Ask for:	Chris Spong
Telephone:	01832 742351
Planning Services	
Our Ref:	NE/21/01689/FUL
Your Ref:	PP-10370736
Date:	25 November 2021

Proposal : **Erection of 6 dwellings and detached garages, alterations to existing vehicular access, and new pedestrian access onto Church Street including white lining on highway with associated engineering works including retaining walls, fencing, parking and turning facilities, drainage and landscaping. at Hill Top House Church Street Hargrave Wellingborough Northamptonshire NN9 6BW .**

I refer to the above application received on **19 November 2021** but have to advise you that it is **INVALID/INCOMPLETE**. In order to enable further progress to be made, please supply the following:

**DRAWING SHEET;**  
 PALOMINO (a)  
 FLOOR PLANS

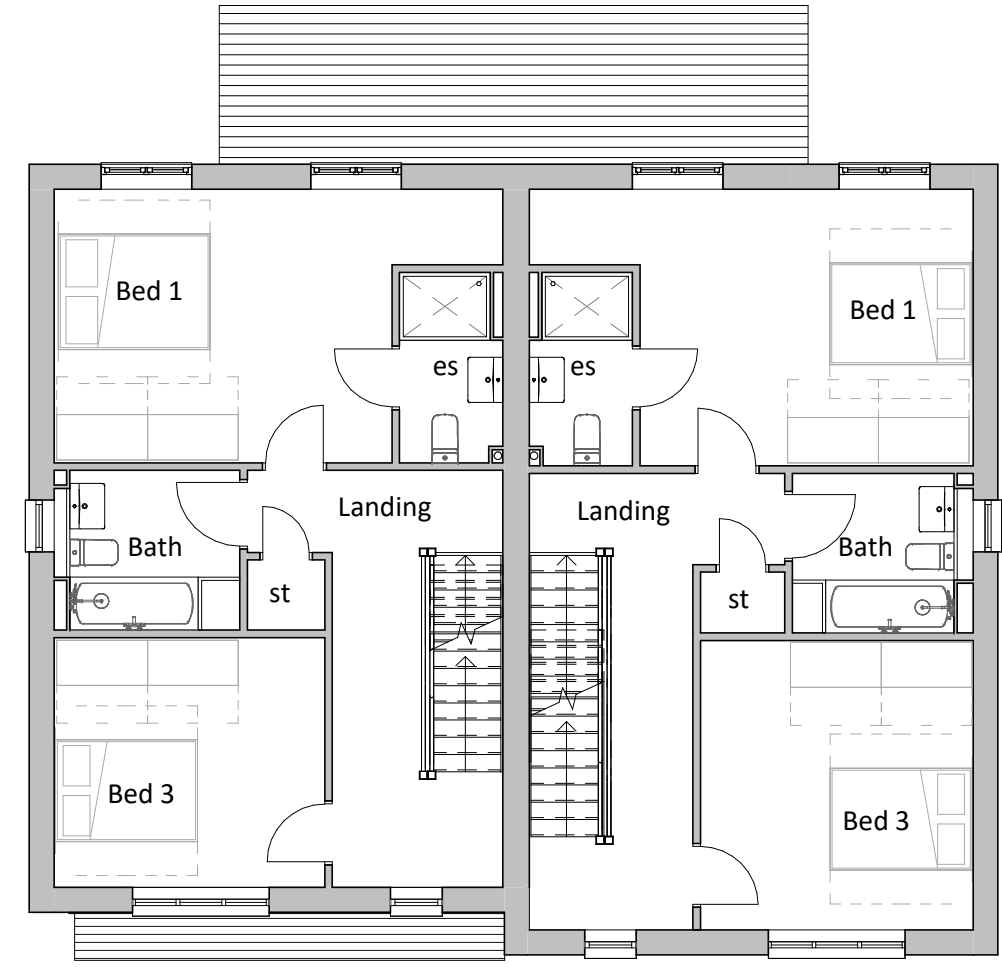
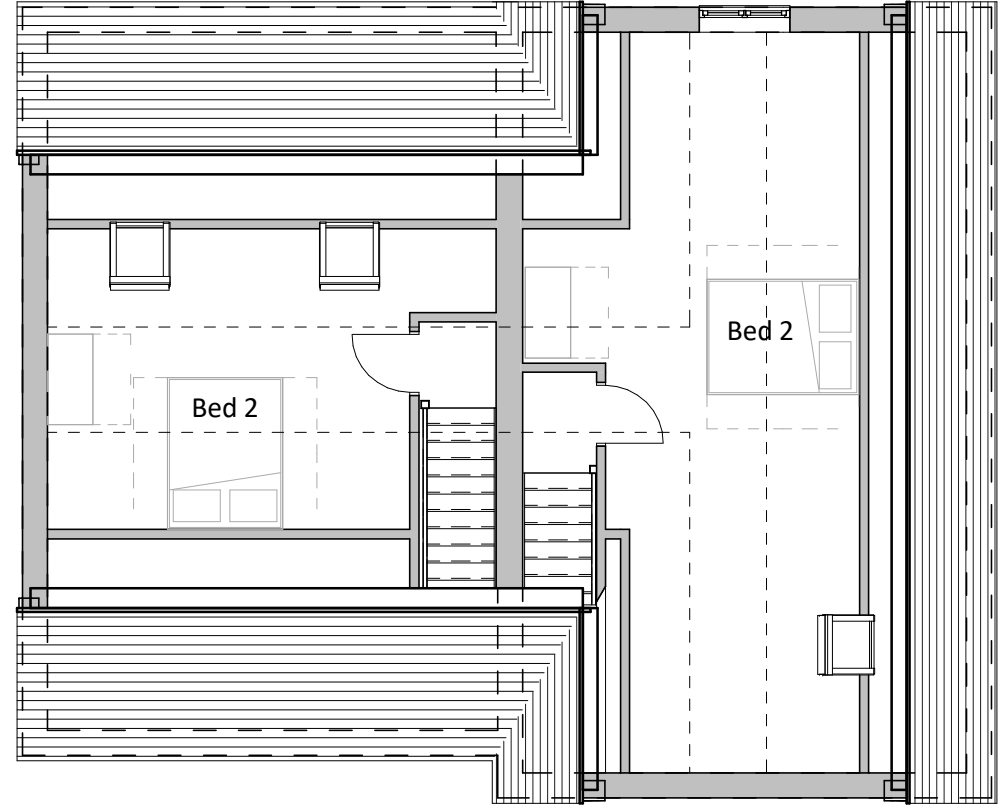
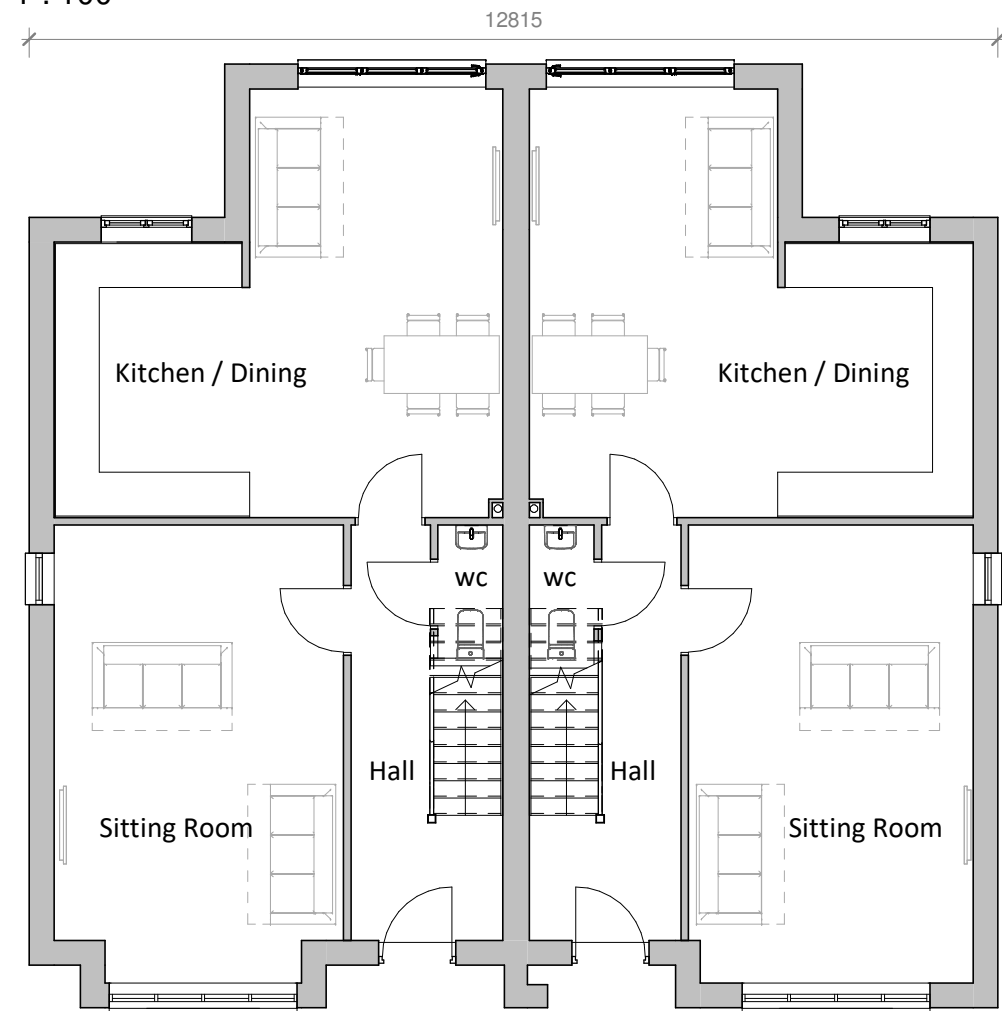
1. As per our published Local Requirements, "All plans and drawings must be drawn to an appropriate metric scale and have all relevant dimensions of the key elements of the proposal clearly written. This includes the height, length, width and (if relevant) the distance from the site boundary of any proposed works. We require this so that the proposed dimensions are clear when plans are viewed online." This is required as we now run a completely paperless planning office. Please provide amended drawings including all relevant dimensions of the proposal.
2. As identified within the 'Site Layout' and 'Indicative Street Scene & Site Section' the Palamino property type appears to be mirrored. Although only a minor detail, to avoid any ambiguity, please provide the mirrored floor plans of the Palamino property.
